Department of Planning and Environment

Our ref: DOC22/1132863

Your ref: SSD-14378717

Subject: EHG comments on Additional Response to Submissions for Telopea Concept Plan and Stage 1 (SSD-14378717)

Figure 1 Telopea Concept Plan Area Lot Boundaries

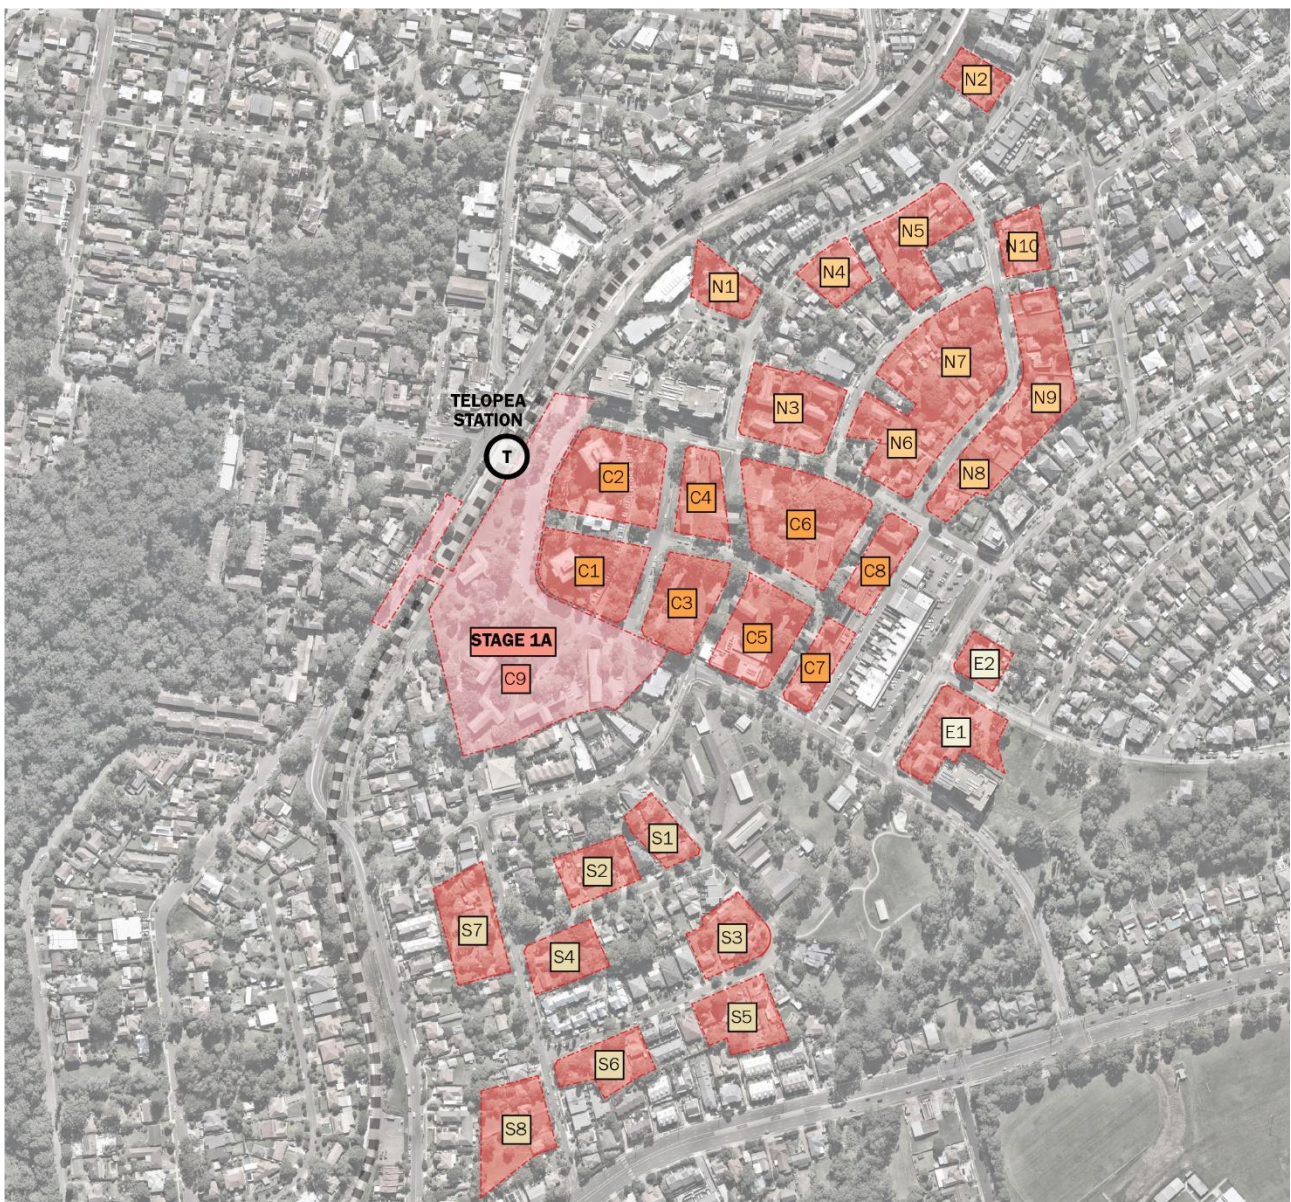
The documents accompanying the ARtS include differing information on the Telopea Concept Plan Area (CPA), for example:

- Section 1.4 of Appendix Y states “the Telopea CPA site is approximately 13.4 (ha)” while Section 1.8 of Appendix Y states “The total area of the Telopea CPA development plan as depicted in Figure 4, equates to about 18.85ha” and Section 4.3.3 of Appendix Y refers to 18.85 ha as the construction footprint.
- Appendix AA states “The Telopea Estate site is approximately 13.4 (ha)” (section 2.2.2).
- Appendix BB states “The Telopea Estate site is approximately 13.4 (ha)” (section 2.2.2).

The applicant should clarify the total area of the Telopea CPA.
